Our Ref: BR/307/19/HH
Your Ref:

Town & Country Planning Act 1990 (as amended)
Town & Country Planning (Development Management Procedure) (England) Order 2015
Application for Planning Permission for Works or Extension to a Dwelling

Development Homeowner is severely disabled and requires the creation of new steps, handrail, a top step level platform with a level threshold door. Work was brought forward due to the homeowner being unable to access the community.

Location 34 Hawthorn Road Bognor Regis

Drawing Title Existing & Proposed Access Route Plan

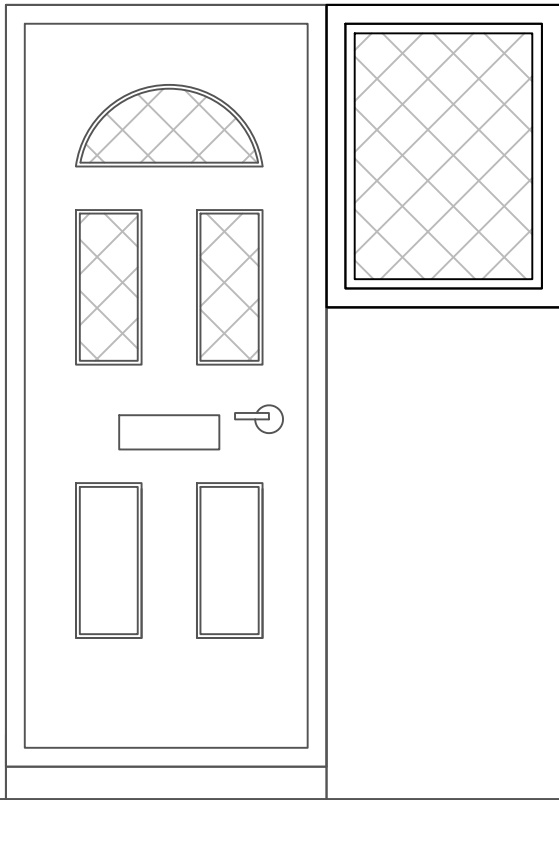
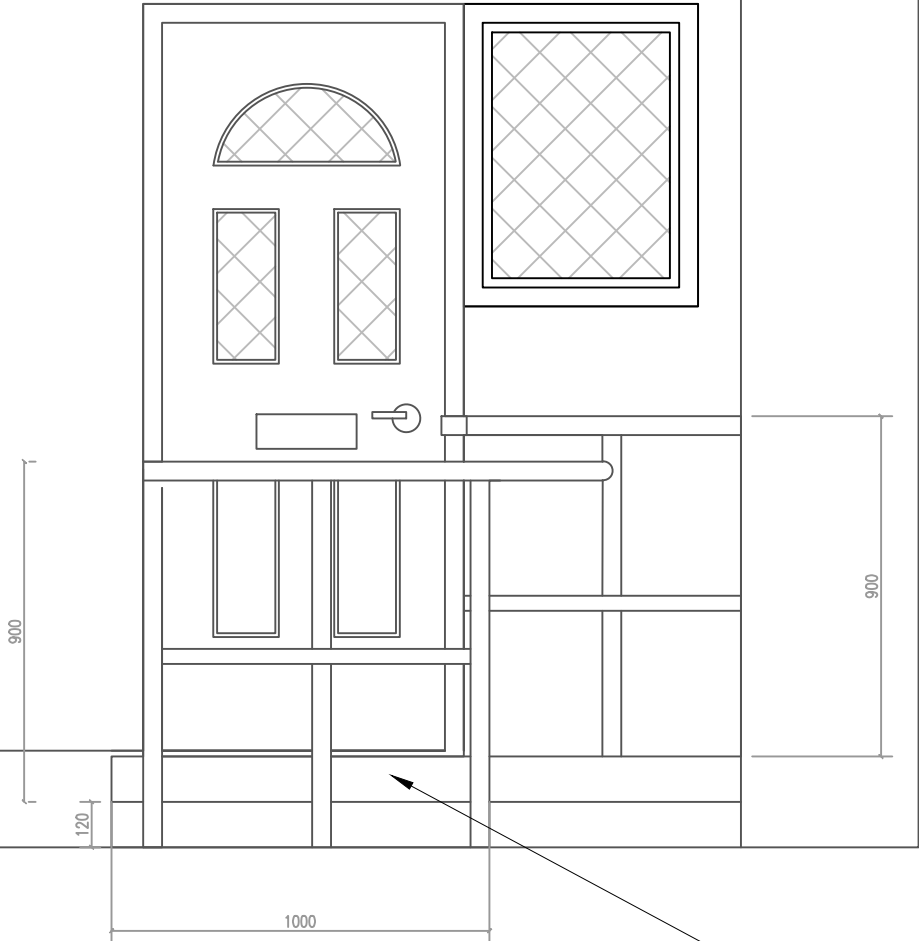
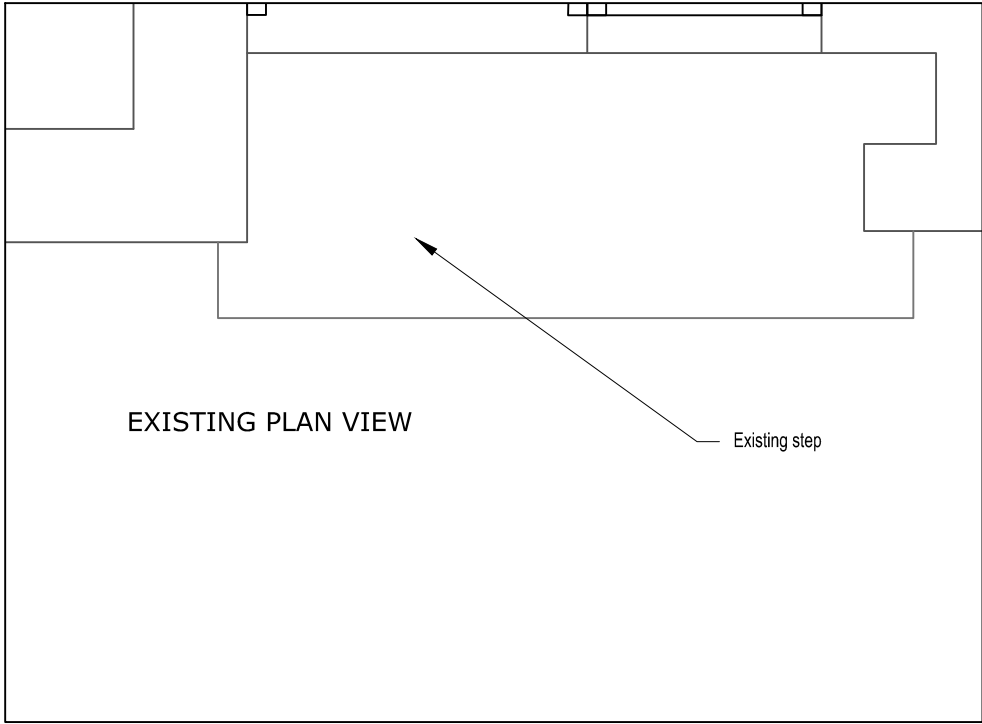
Block plan: Please provide a proposed block plan showing the location of the ramp which includes dimensions from the ramp to all surrounding site boundaries.

Drawing Title
Proposed Step Access Details

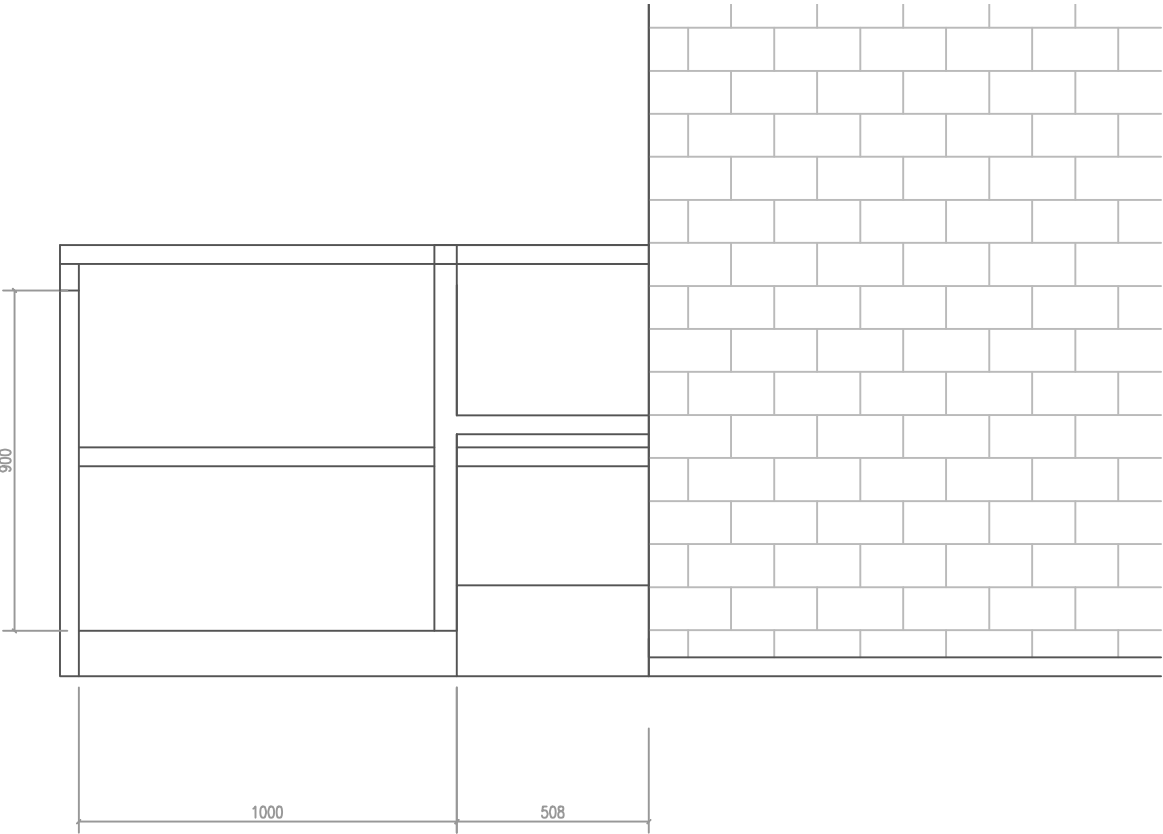
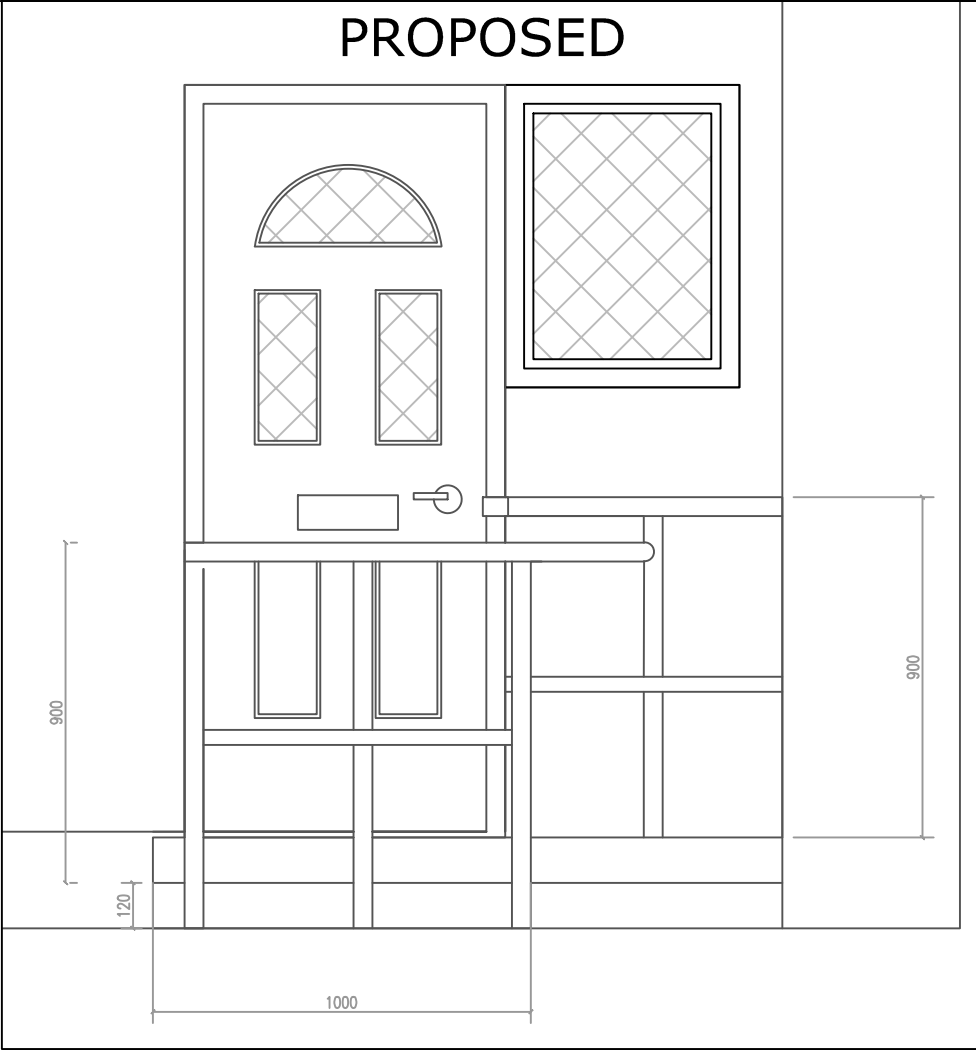
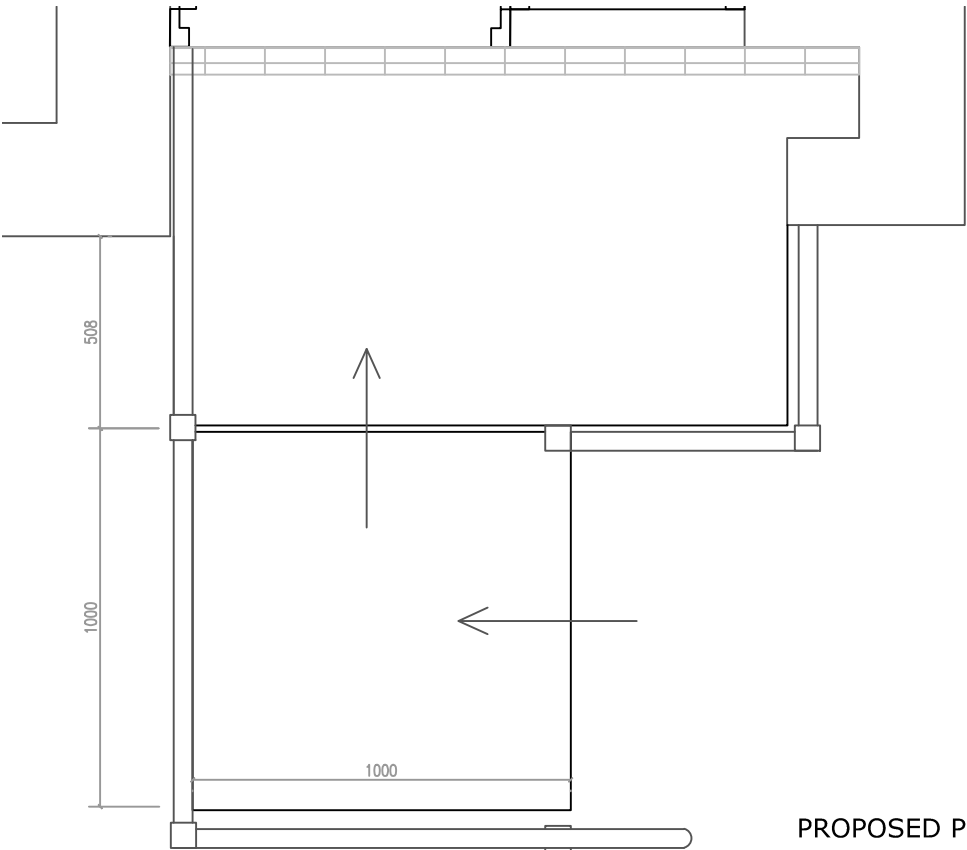
Side Elevations: Please provide the side elevations for the proposed ramp.
